**RE: RESPONSE TO ADDITIONAL QUERIES SSD-76555711 – 3-5 HELP STREET, CHATSWOOD**

This letter has been prepared by Mecone on behalf of Loftex Chatswood Pty Ltd (the applicant) in relation to the State Significant Development Application (SSDA) SSD-76555711 for 3-5 Help Street, Chatswood (the site).

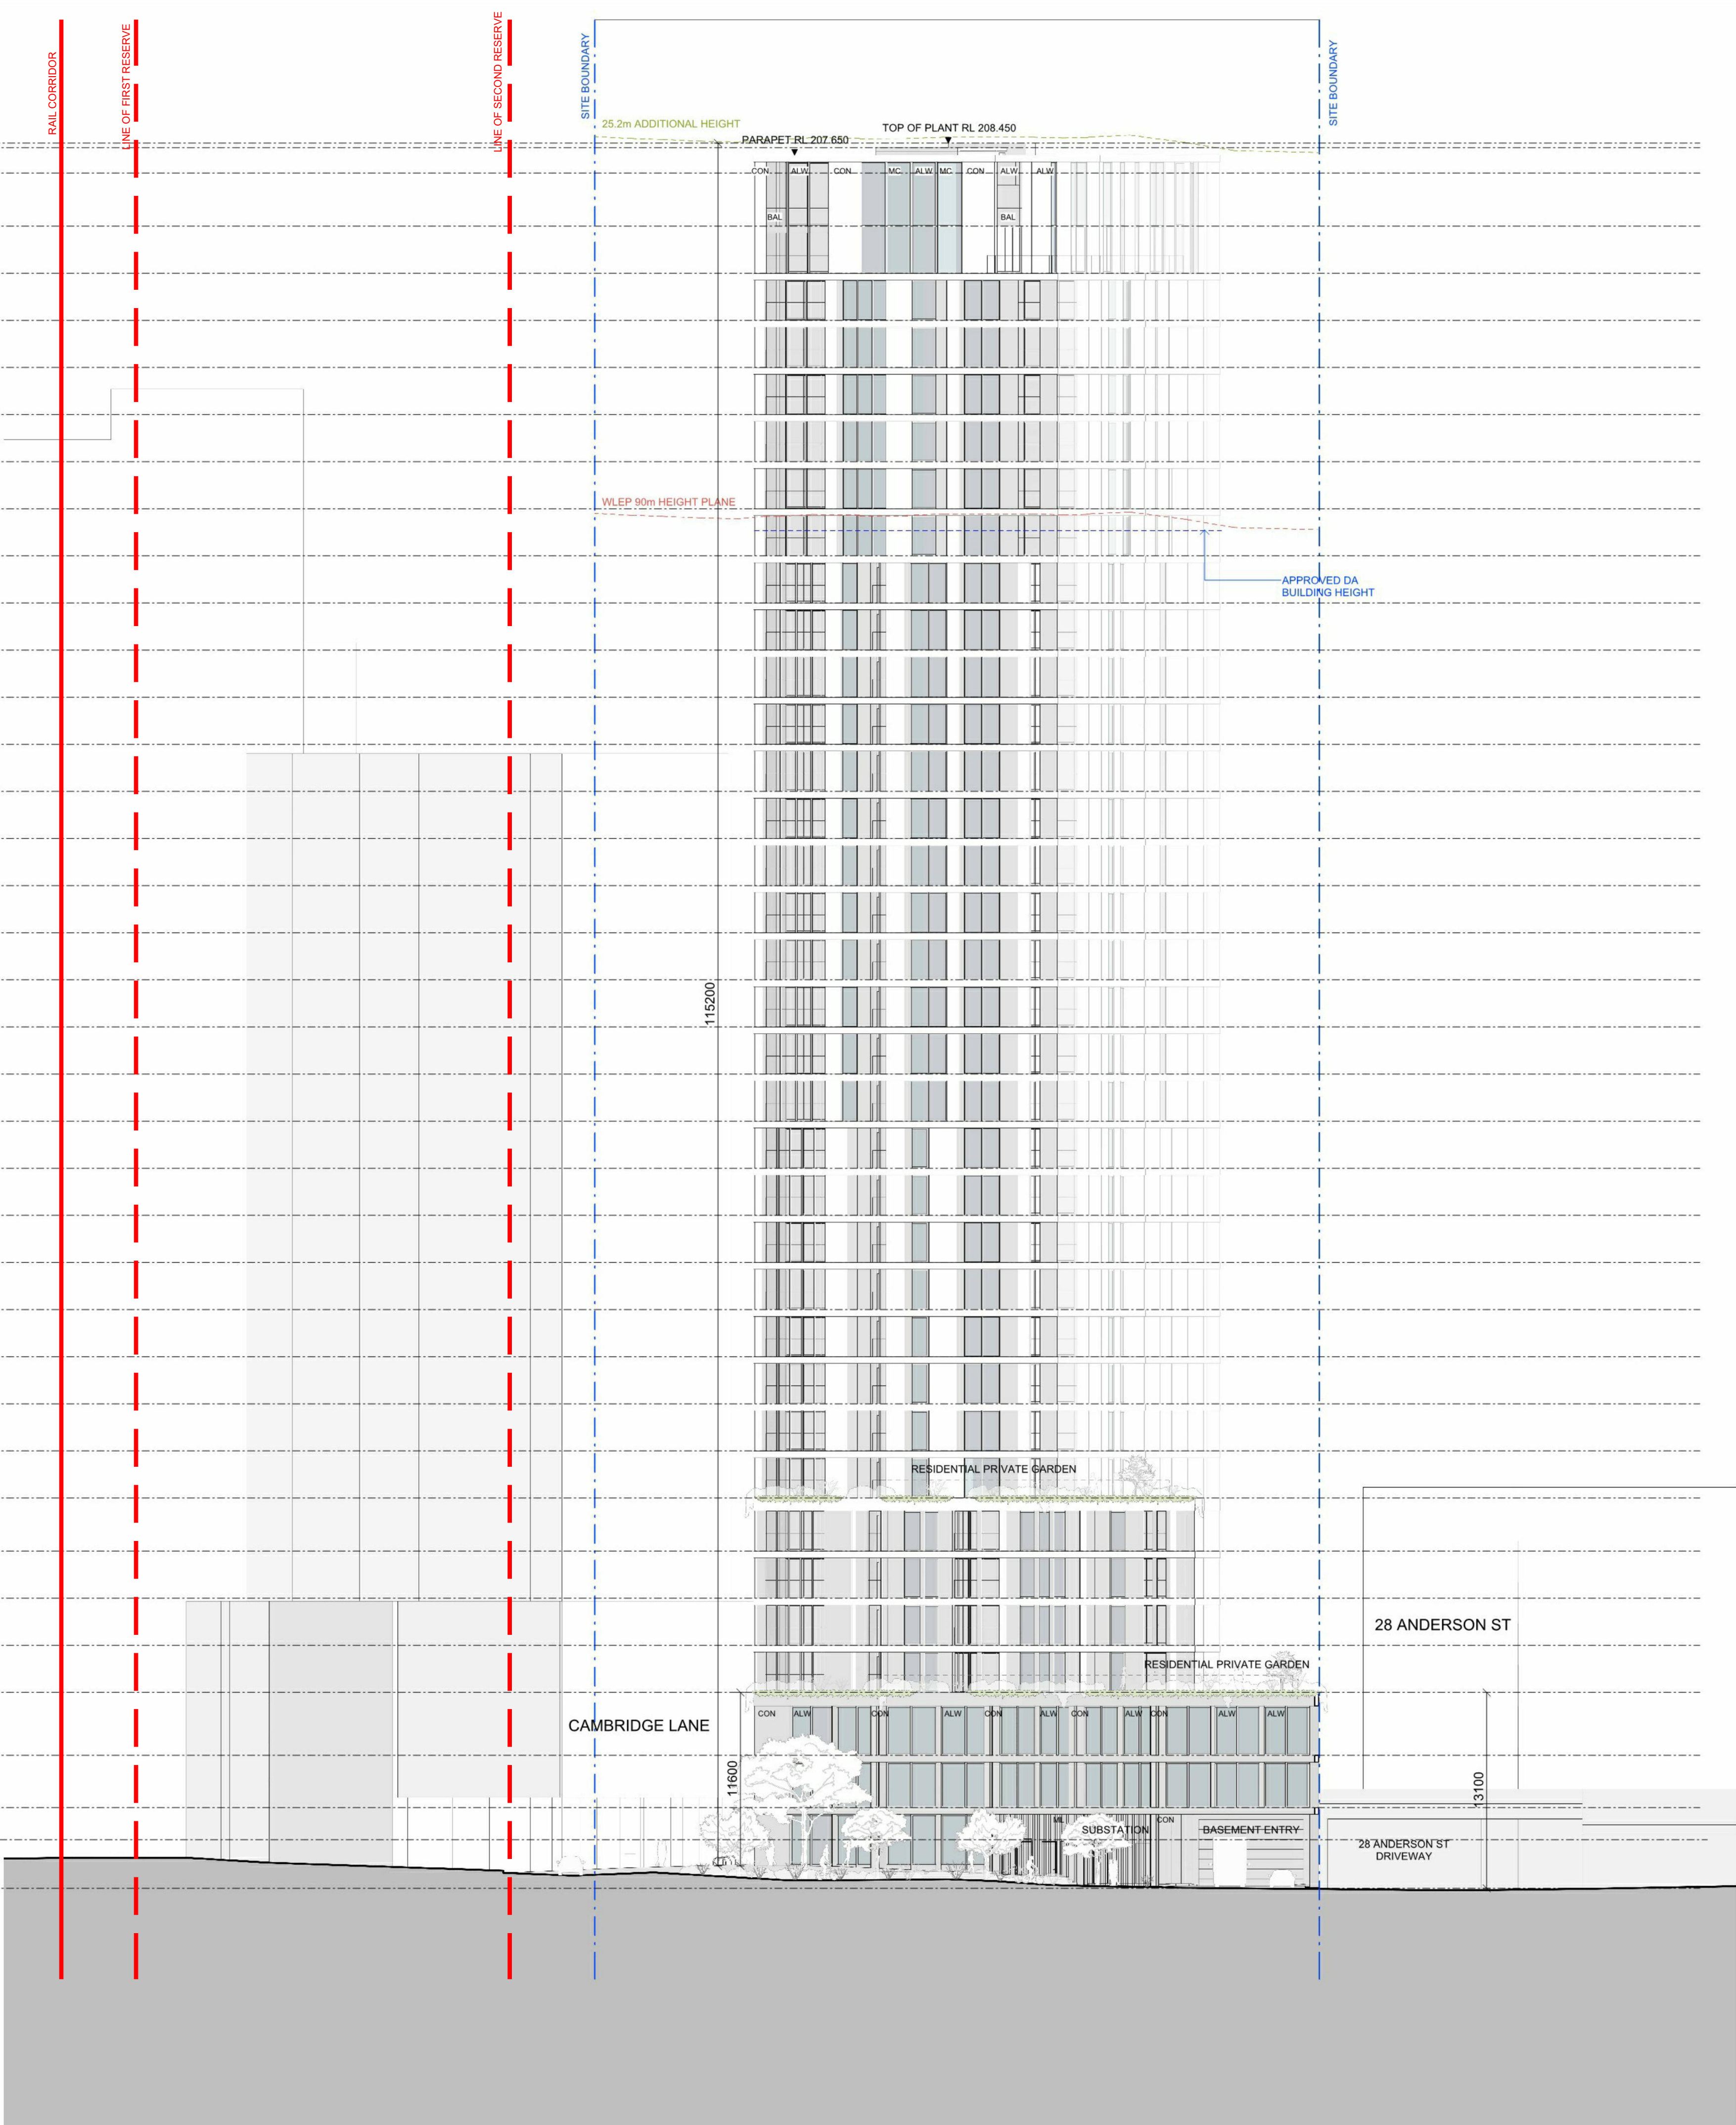
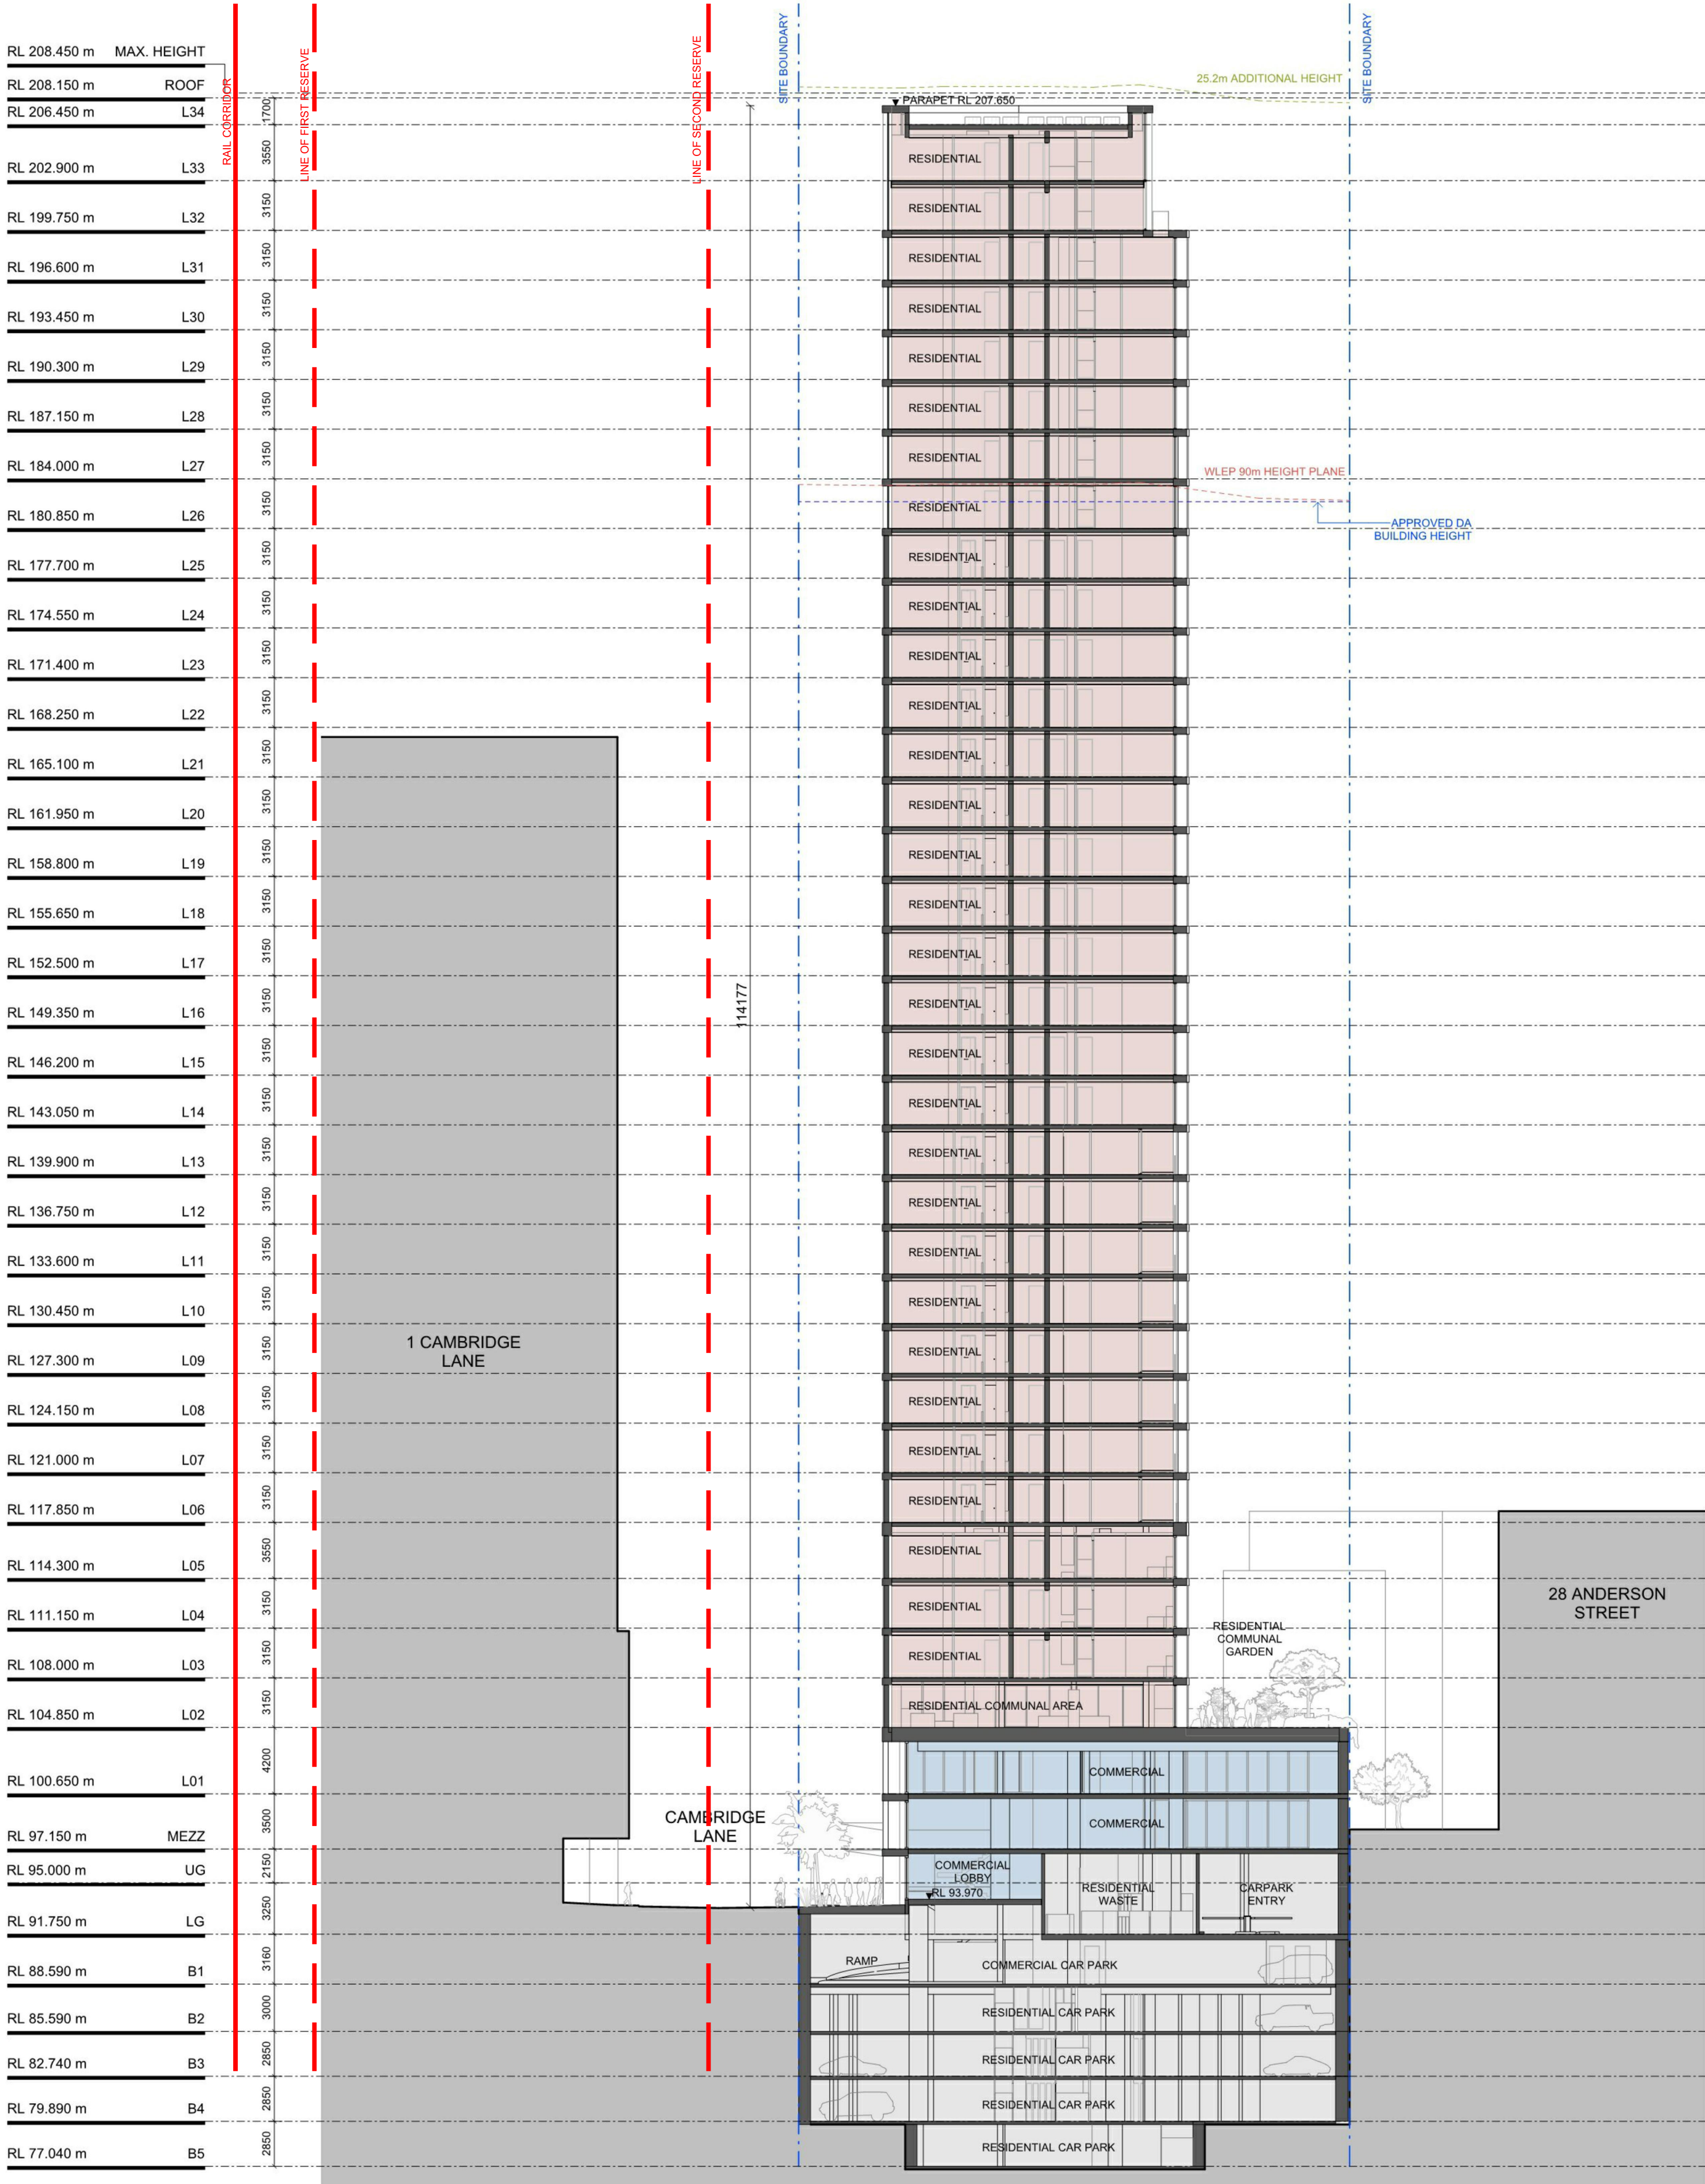
- *Elevation/section verified by Surveyor showing the metro protection reserves and development site.*

As requested, the Sections showing the metro protection reserves have been prepared and verified by a Surveyor at **Attachment 4**.
